RE: Existing Tank Application # BRES2008-0042

Property Location: 216 Clarks Corner Rd. (NC 42 W.)

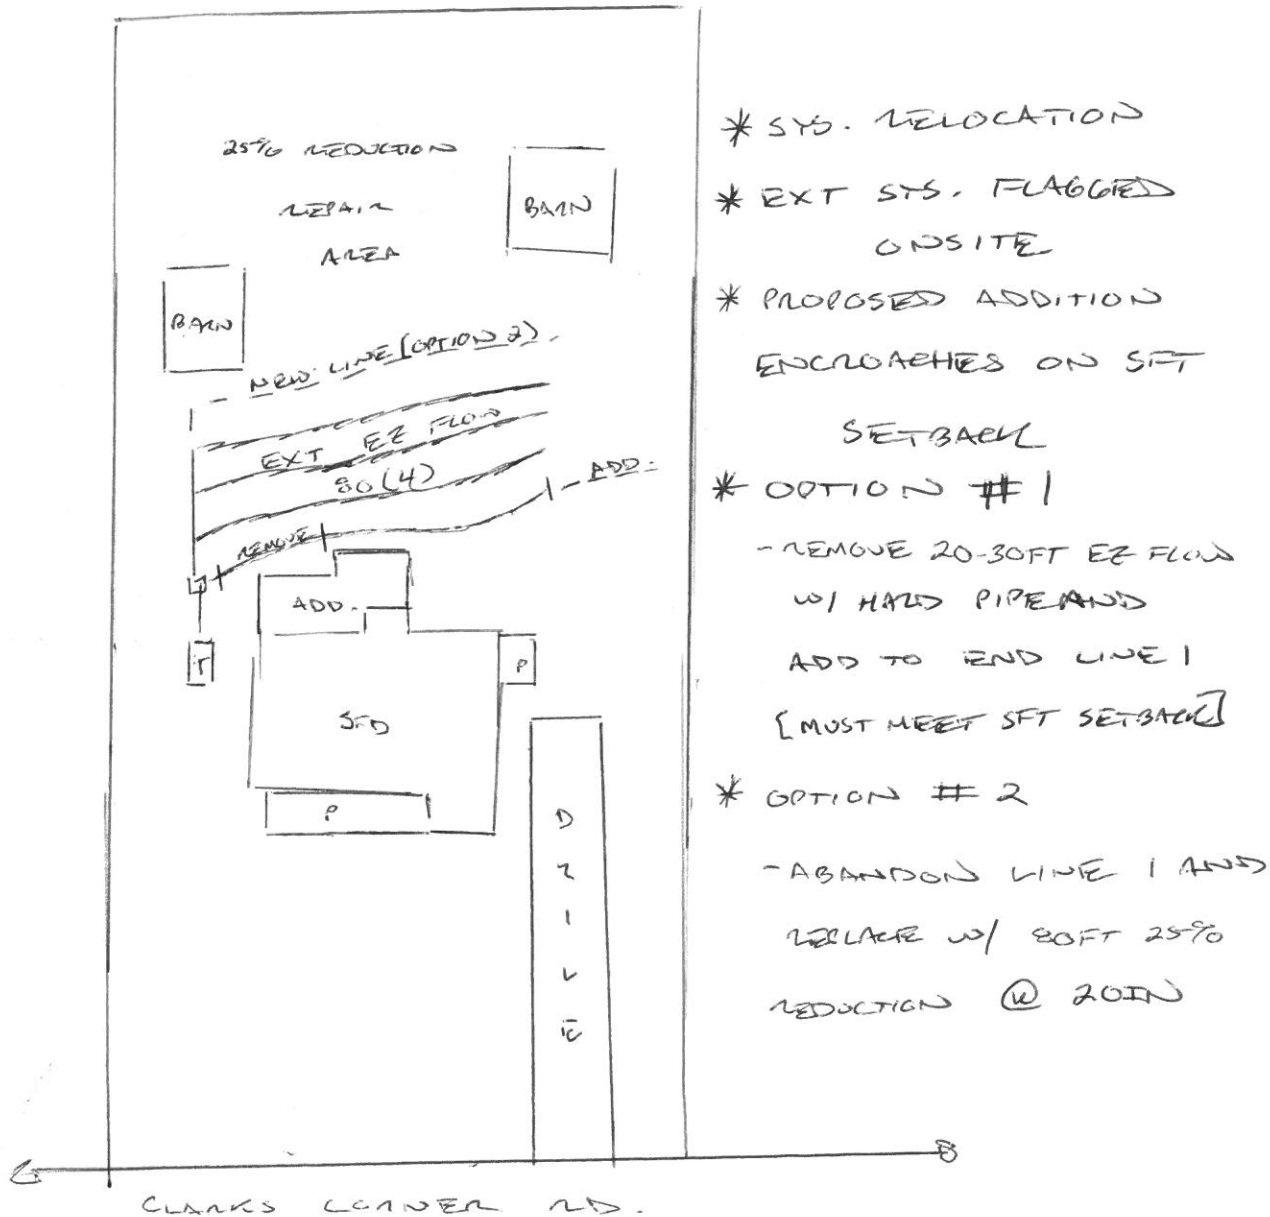
X 4. Other – Septic Encroachment-First line of existing septic system encroaches upon 5ft septic setback (flagged onsite). Proposed additions shall be revised to meet 5ft septic setbacks and/or system relocation shall be applied for with fee for relocation permit for 1st septic line.
